Dated: 8 MARCH 2019

FOREWORD

In an effort to aid the ExA we are submitting comments with evidence in the form of a row under each of the answers provided by the Applicant on a section by section basis

Figure 12.6
Aircraft noise - daytime $L_{Aeq,16hr}$
contours - year of forecast maximum
capacity

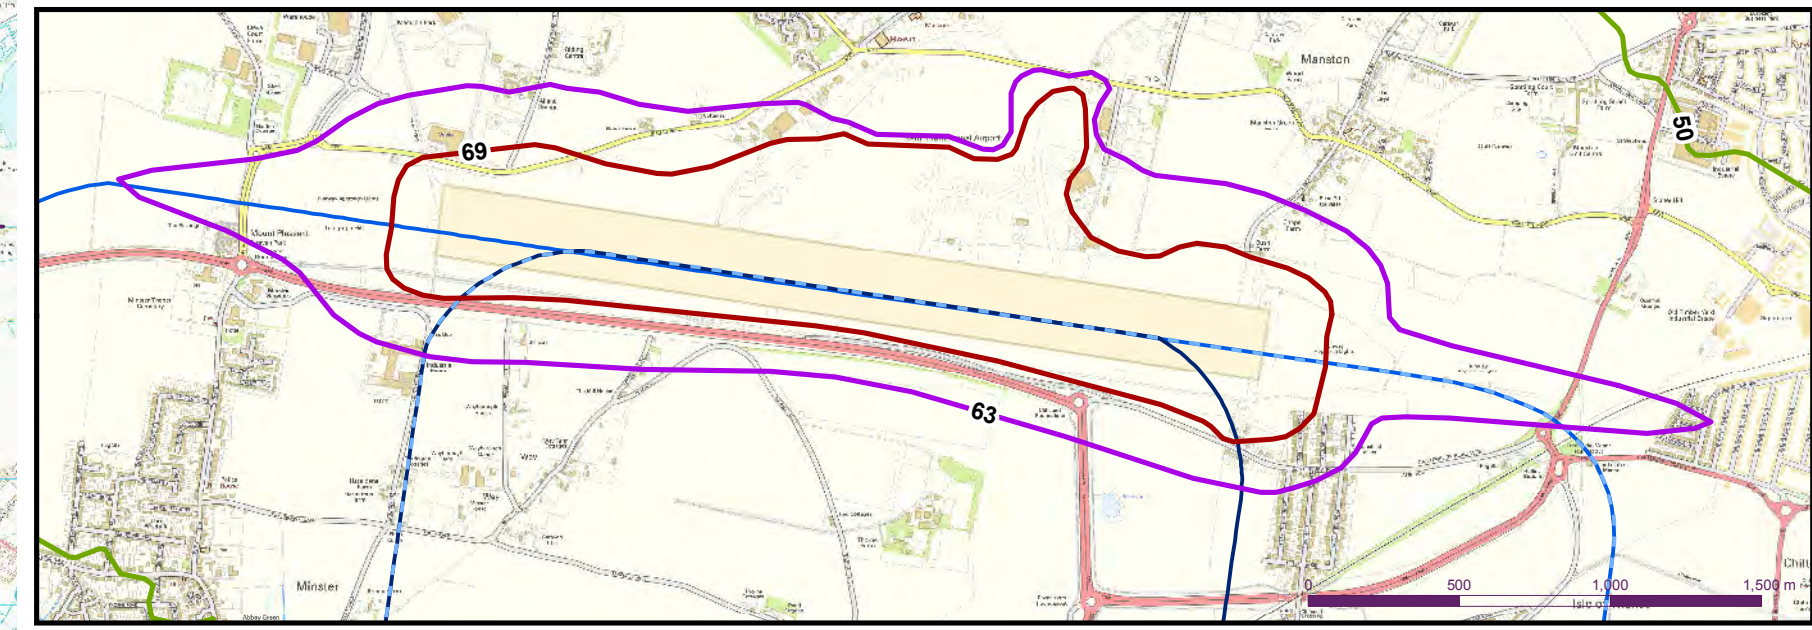
in paragraphs 2.4 and 2.5 of the Noise Mitigation Plan [APP-009] concerning noise insulation funding. Specifically, this relates to: "residential properties with habitable rooms within the 63dB LAeq (16 hour) day time contour' and 'residential properties with bedrooms falling within the 55dB LAeq (8 hour) contour' and the provision of 'reasonable levels of noise insulation and ventilation for schools and community buildings within the 60dB LAeq (16 hour) daytime contour" DDC has noted that these levels are greater than those given with respect to acoustic insulation under the Heathrow Expansion consultation in January 2018 which refers to 60dB LAeq (16 hour) contours for an inner zone and 57dB LAeq (16 hour) contours for an outer zone. In addition, the CAA's recent findings on Aircraft Noise and Annoyance (February 2018) makes reference to UK policy in	Ref No.	Respondent	Question
DDC recommends (as does KCC in [RR- 0974]) that the daytime noise contour of 60dB LAeq (16 hour) used for schools and community buildings is also used as the daytime noise contour qualification for noise insulation. What is the Applicant's view on the DDC recommendation?	Ns.1.1	The Applicant	Dover District Council (DDC) has noted that properties in the Dover District fall outside of the noise contours as referred to in paragraphs 2.4 and 2.5 of the Noise Mitigation Plan [APP-009] concerning noise insulation funding. Specifically, this relates to: "residential properties with habitable rooms within the 63dB LAeq (16 hour) day time contour' and 'residential properties with bedrooms falling within the 55dB LAeq (8 hour) contour' and the provision of 'reasonable levels of noise insulation and ventilation for schools and community buildings within the 60dB LAeq (16 hour) daytime contour" DDC has noted that these levels are greater than those given with respect to acoustic insulation under the Heathrow Expansion consultation in January 2018 which refers to 60dB LAeq (16 hour) contours for an inner zone and 57dB LAeq (16 hour) contours for an outer zone. In addition, the CAA's recent findings on Aircraft Noise and Annoyance (February 2018) makes reference to UK policy in relation to an 'annoyance threshold' and highlights 57dB LAeq (16 hour) as marking the approximate onset of significant community annoyance. DDC recommends (as does KCC in [RR- 0974]) that the daytime noise contour of 60dB LAeq (16 hour) used for schools and community buildings is also used as the daytime noise contour qualification for noise insulation.

As you will be aware PHE identified that a large number of sensitive and vulnerable people live under the
	flight swathe.
	Applicant should evidence why it does not share PHE concerns.

Applicant's Response:
	Noise insulation is included in the Noise Mitigation Plan [APP-009] to avoid significant adverse effects of noise as required
	by the first bullet point of paragraph 5.68 of the Airports National Policy Statement and in accordance with the first aim of
	government noise policy. For the purposes of this proposal, the Significant Adverse Effect Level (SOAEL) has been set at

Ref No.	Respondent	Question
		63 dB LAeq,16h. Government policy states that above this threshold, significant observed adverse effects on health and quality of life can begin to be observed in an average person.
		DDC makes a comparison with Heathrow's proposed noise insulation scheme. We do not consider it appropriate to compare Manston Airport with Heathrow in terms of likely noise impacts. A resident living within Heathrow's noise insulation "inner zone" may have approximately 600 aircraft per day fly overhead (approximately one every 90 seconds), whilst a resident located within the Manston 60 dB LAeq,16h noise contour may have up to 36 aircraft fly overhead per day in the peak operating year (approximately 4 – 5 aircraft per hour).
		DDC also make reference to the CAA's recent findings on Aircraft Noise and Annoyance (CAP 1588 February 2018). The statement quoted, provided in its full context below, is with reference to the Government's 2003 White Paper (The Future of Air transport Dec 2003) and subsequent Aviation Policy Framework 2013:

Figure 12.7
Aircraft noise - night-time $L_{Aeq,8hr}$
contours - year of forecast maximum
capacity

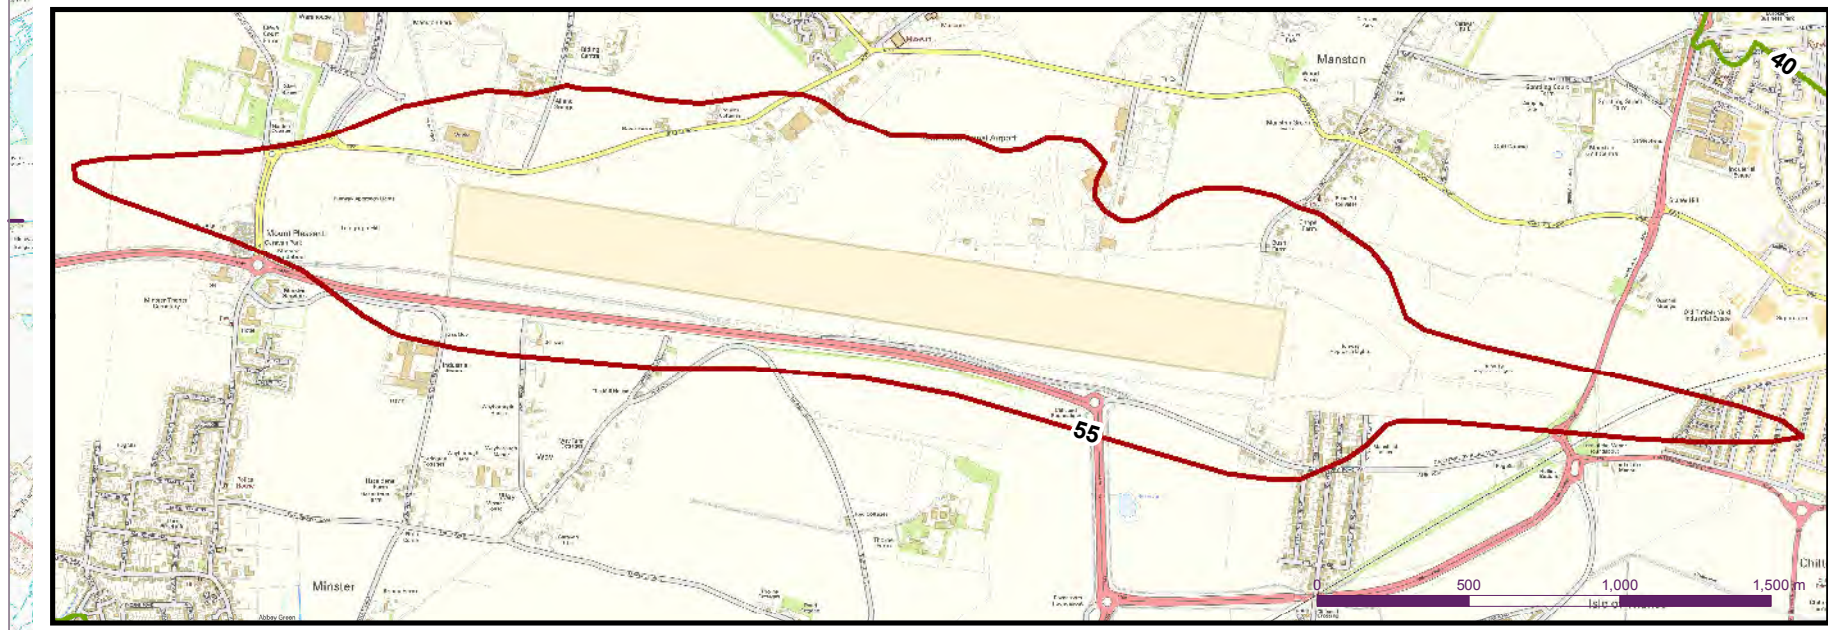
Ns.1.2	The Applicant	KCC [RR- 0974]
		Paragraph 12.5.8 of the Environmental Statement [APP-034] describes the measures in the Noise Mitigation Plan [APP-
		009] and one of these is a voluntary quota count system.
		The Annual Quota Count is 3,028 (this is for noise emissions, not number of movements, between 23:00 and 07:00). The proposed quota equates to approximately 8 quota count points per night and given that paragraph 12.7.40 of the ES [APP-
	1	proposed quota equates to approximately o quota count points per hight and given that paragraph 12.7.40 of the ES [AFF-

Ref No.	Respondent	Question
		034] states the forecast is to handle 7 aircraft during a typically busy night period, this is possible (given a QC/1 aircraft would use one of those points).
		The Noise Mitigation Plan currently has no dates on it.

i. How long does the Applicant propose the quota count system will apply?
		ii. When would it be subject to review and by whom?
		Applicant's Response:

i. The question's description of the Night Noise Quota component of the Noise Mitigation Plan [APP-009] described in the Environmental Statement [APP-034] is correct. The Applicant proposes that the quota count system will apply in perpetuity, or until agreed to no longer be required by the Local Planning Authority or other relevant authority.
		ii. If it were decided to amend the quota count, then this would be effected via an application to the Secretary of State to amend the DCO.
		This is too onerous and unreasonable condition. It is also against the regulatory and statutory law in relation to noise. 7 aircraft a night is not a worse case realistic quantification of Quota Count. If every aircraft had a quota count of 1 on take-off (landing 0.5) we could end up with over 6000 ATMs a year which would mean 17 flights a night.
		It is not just the flights it is the associated road traffic (fuel, tankers, passengers and workers) as well as the loading and unloading of freight.
